Application Ref:	3/2025/0933	 Ribble Valley Borough Council www.ribblevalley.gov.uk
Date Inspected:	N/A	
Officer:	MC	
DELEGATED ITEM FILE REPORT:		REFUSED

Development Description:	Certificate of Lawfulness for the existing building operations associated with the conversion of barn and for the use as residential care accommodation (C2 use).
Site Address/Location:	Cow Hey Brook Barn Twitter Lane Bashall Eaves BB7 3NA

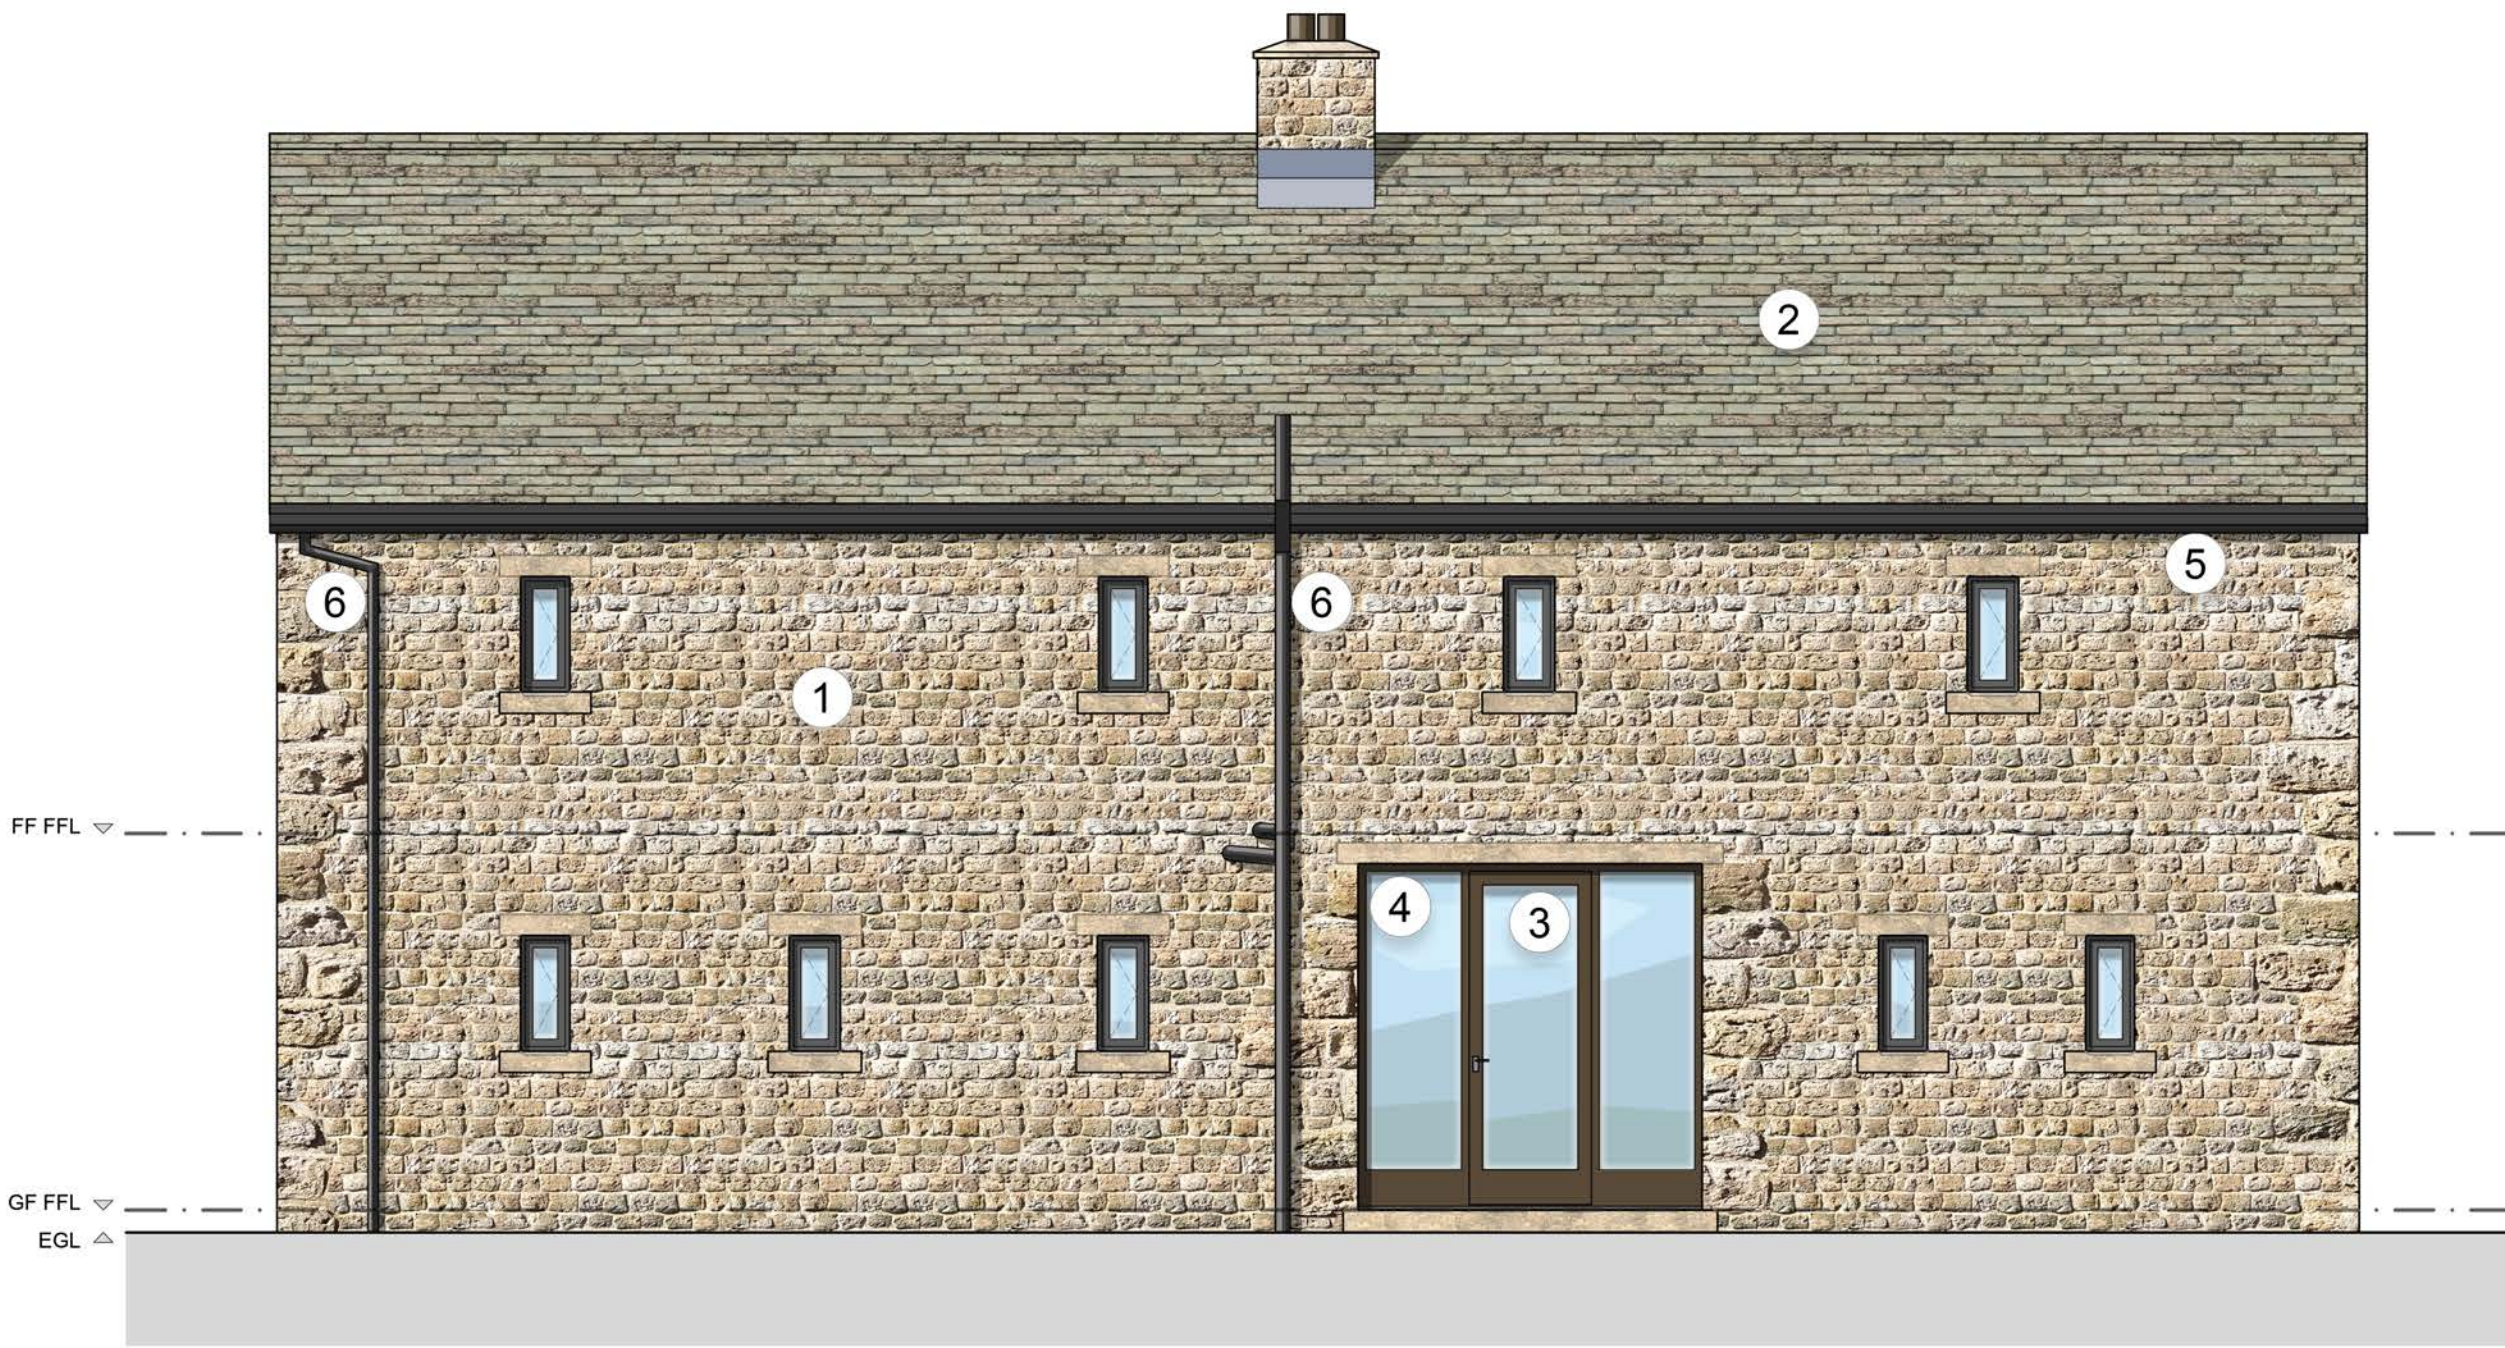
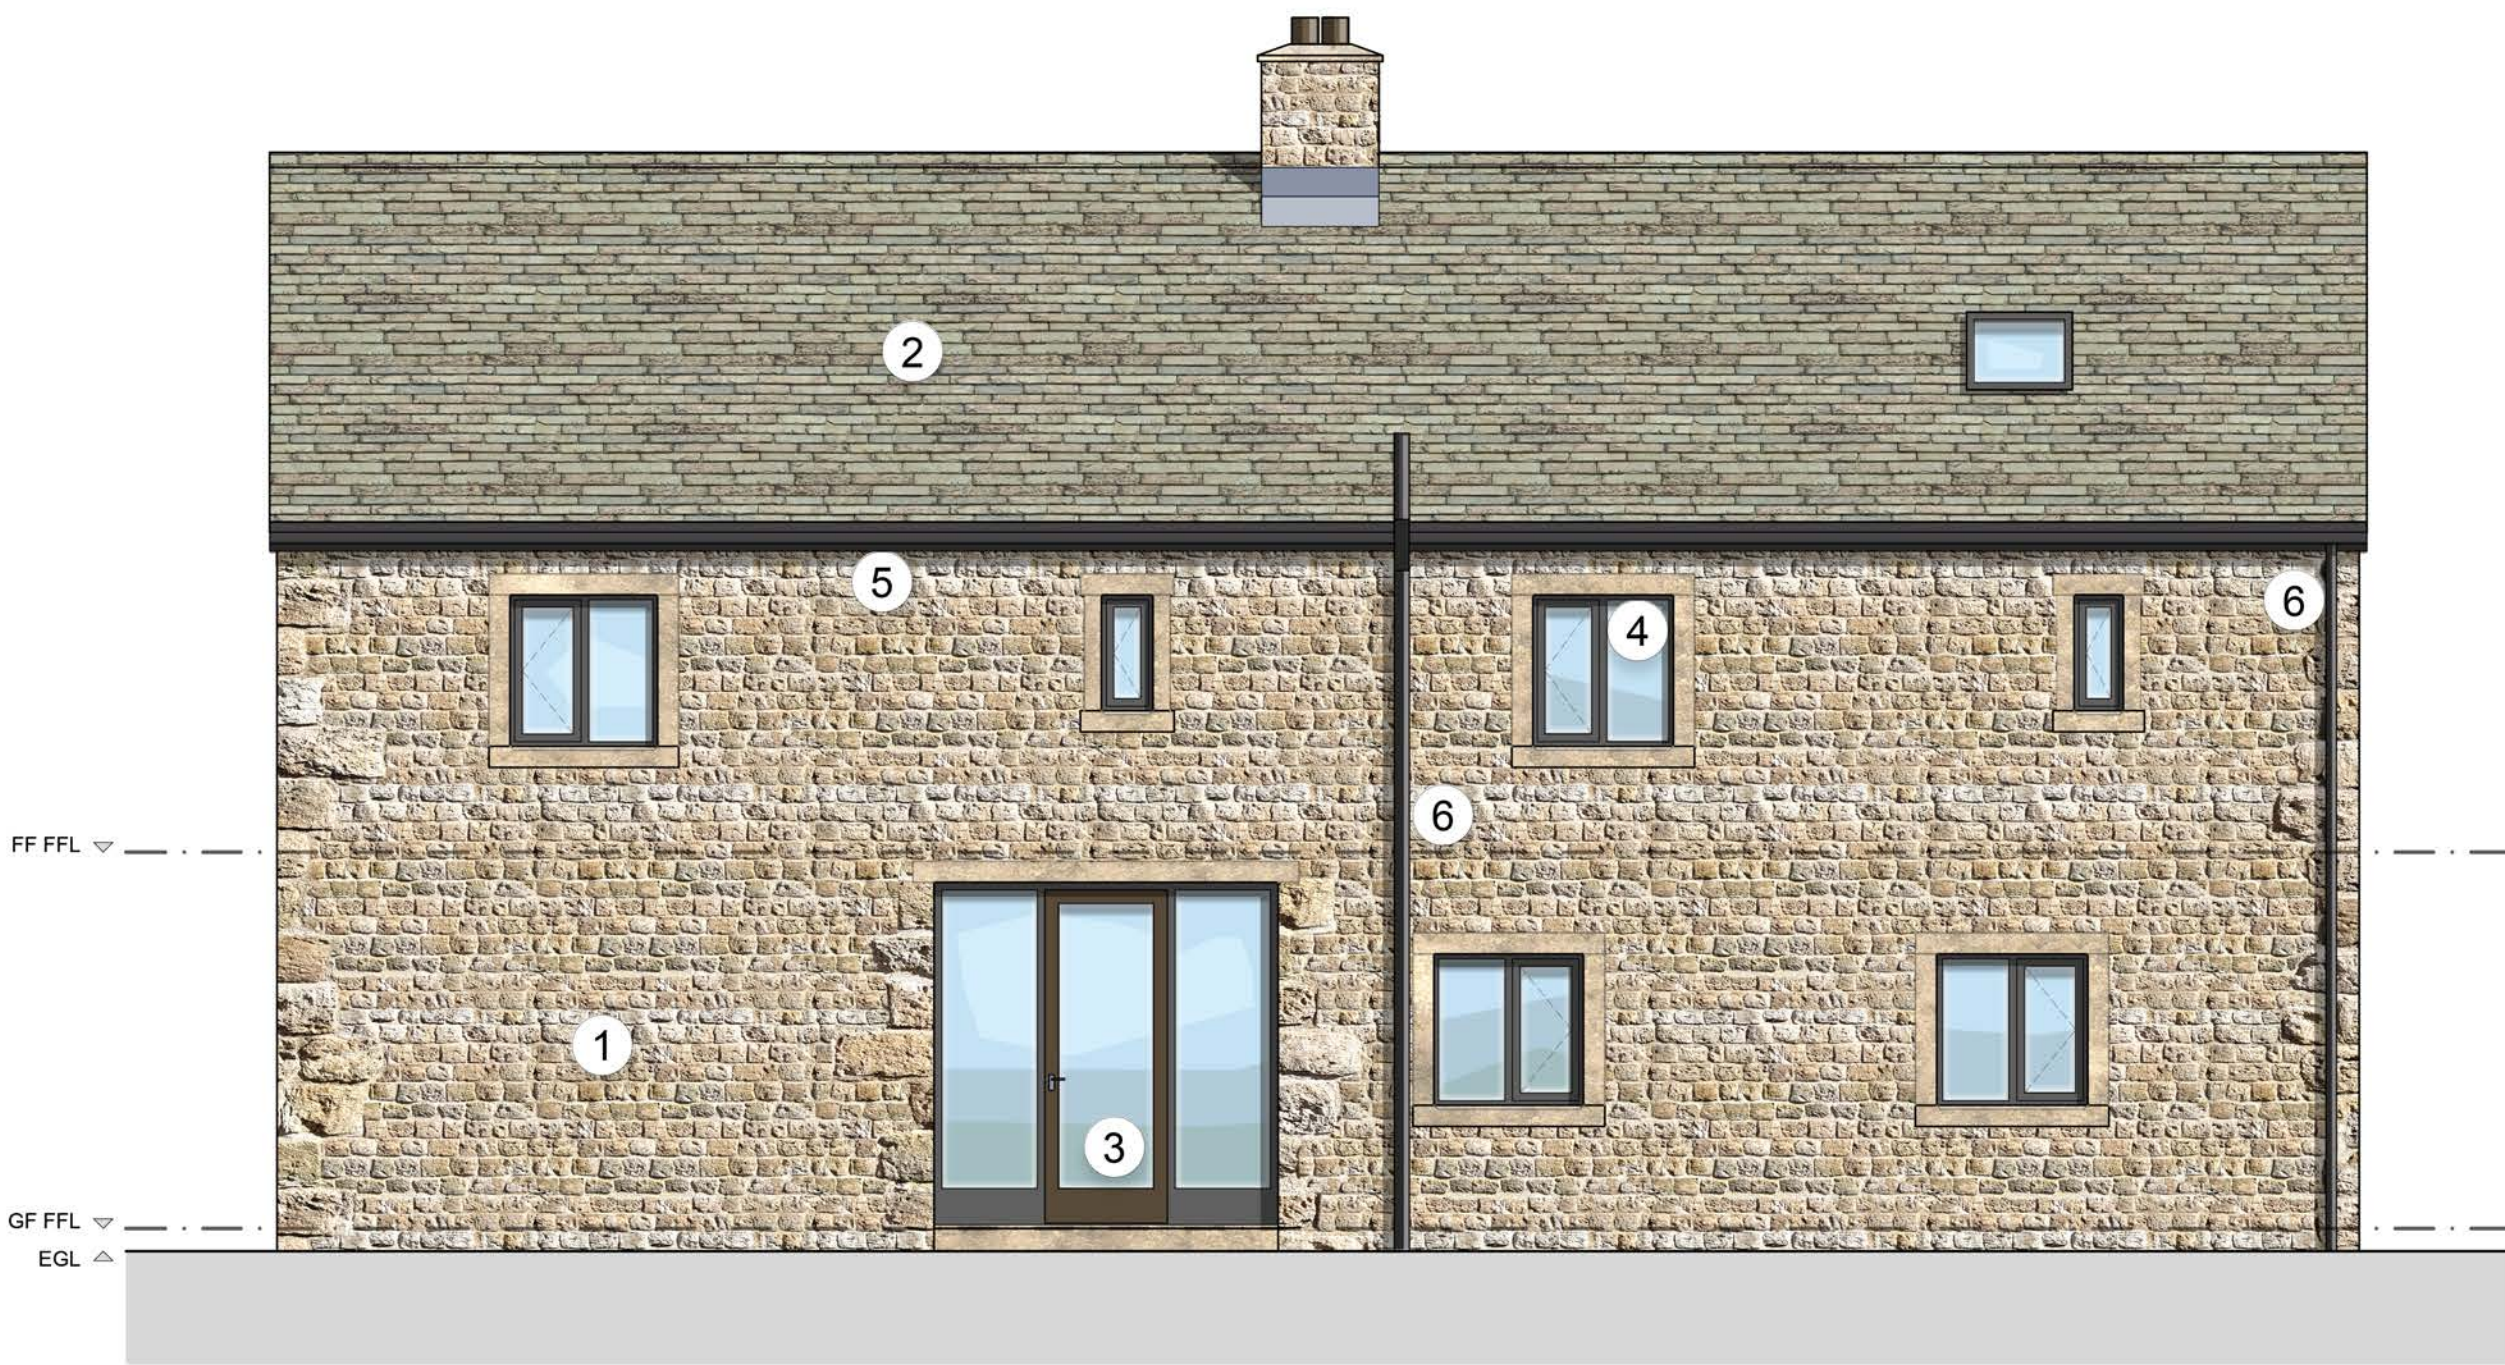
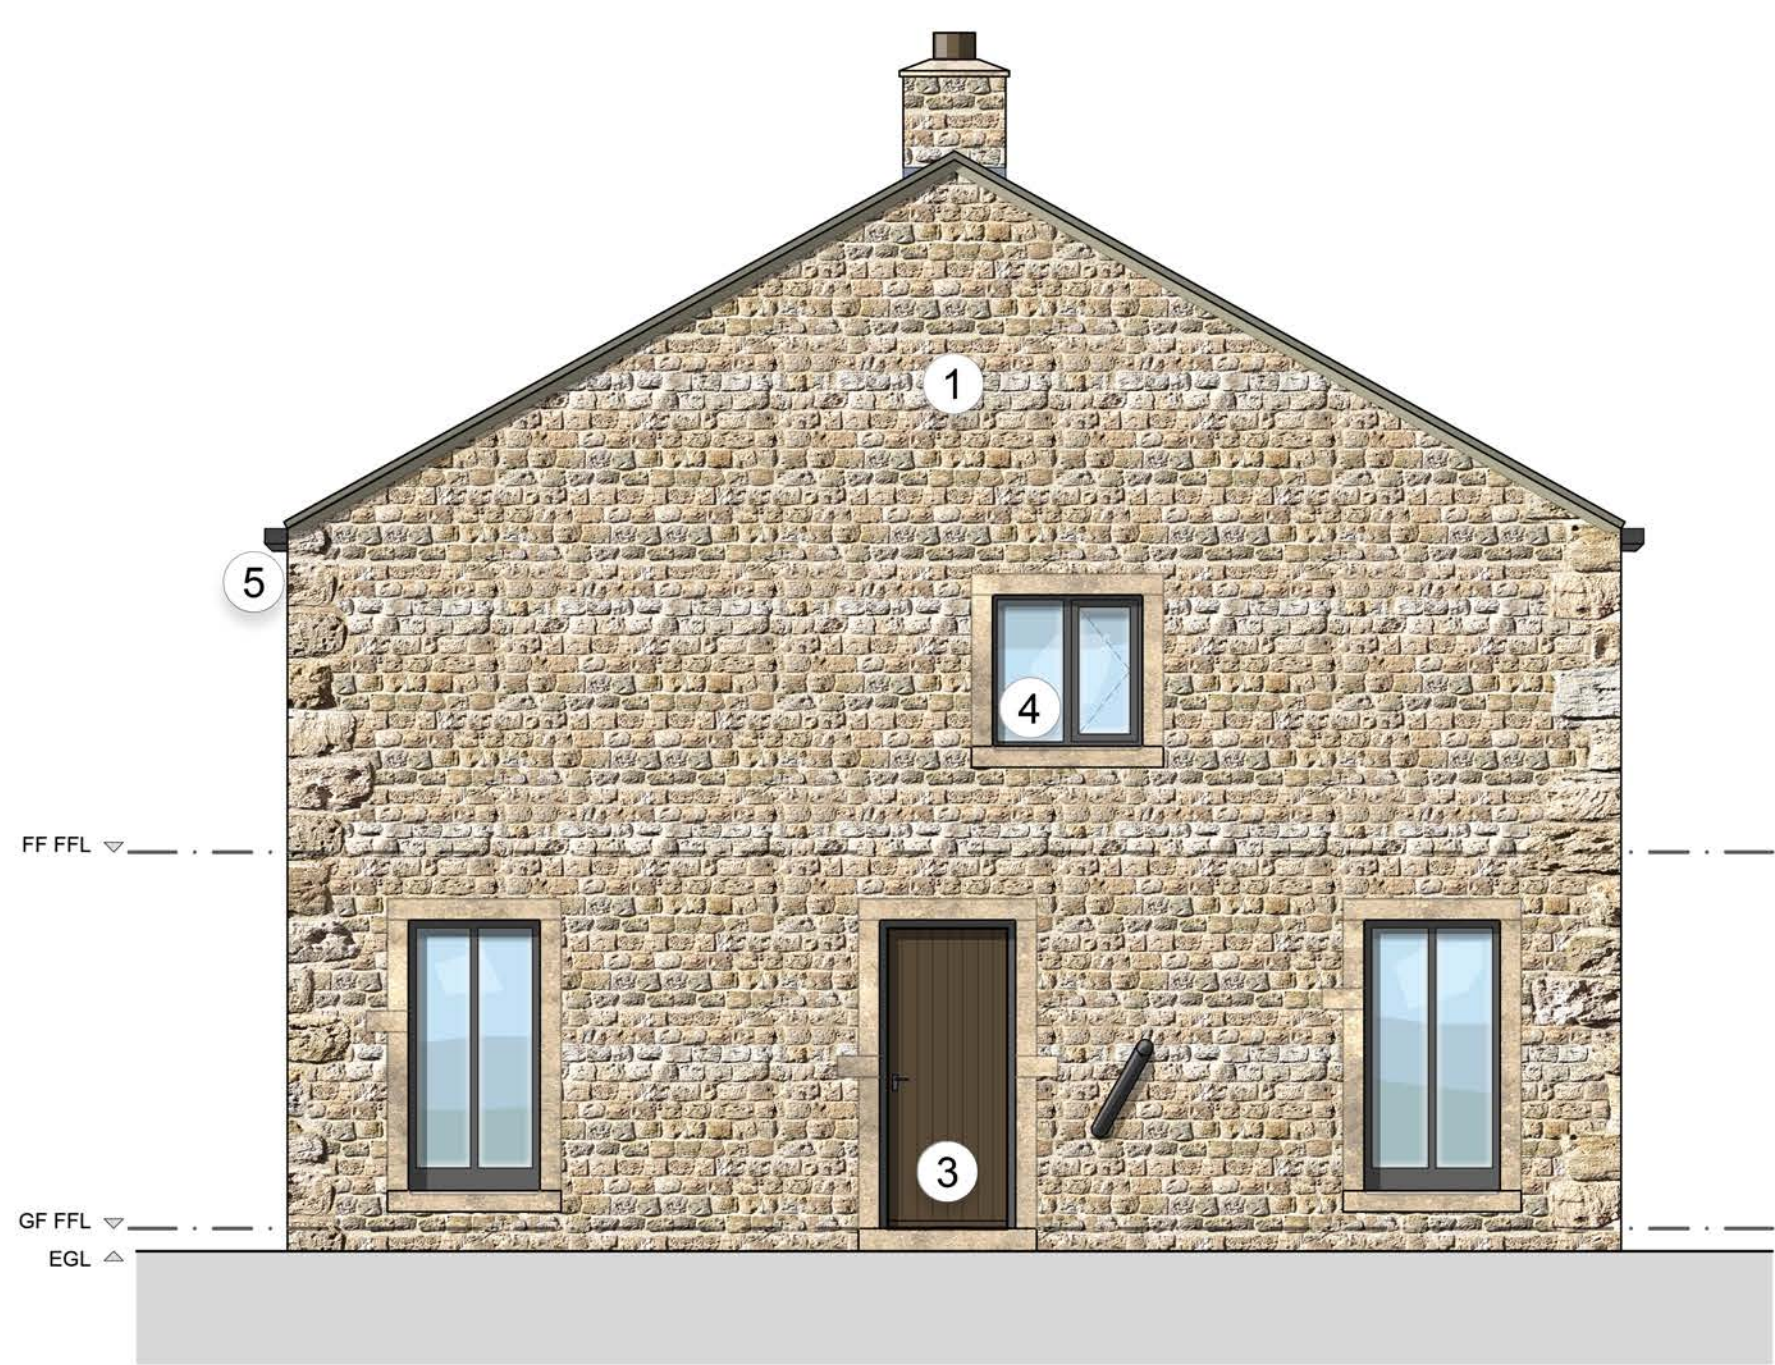
When comparing the submitted elevation drawings to the elevation drawings approved under planning ref: 3/2002/0056, there are a number of external alterations. These include:

- Insertion of additional first floor window to the west and east elevations
- Alterations to door size/design to west and east elevations
- Alterations to window stone surrounds to ground floor windows of north and south elevations

The application form states that the building operations were substantially completed more than four years before the date of this application. However, the applicant has not provided any evidence in support of the claim that the building operations took place more than four years before the date of this application. Satellite imagery from 2015, 2021 and 2022 shows part of the eastern elevation of the building and the outline of the front entrance door and the windows to this elevation. However, no information has been submitted, to demonstrate that the building operations to the western, northern and southern elevations were substantially completed four years prior to the date of this application. As such, the application lacks evidence to demonstrate, on the balance of probabilities that the building operations are lawful as per the time requirements of Section 171(B) (1) of the Town and Country Planning Act (1990) (the Act).

On the basis of the available evidence and the balance of probabilities, it is not considered that on the balance of probabilities, the building operations as shown on drawing ref: C1131 021 Rev 0 are lawful by virtue of Section 191 of the Town and Country Planning Act 1990. In addition, it is not considered that on the balance of probabilities, the use of the building and land as shown on drawing ref: C1131 000 Rev 1 and C1131 001 Rev 0 have been continuously used as residential care accommodation (C2 use) for a continuous period in excess of 10 years and therefore is not considered lawful by virtue of Section 191 of the Town and Country Planning Act 1990.
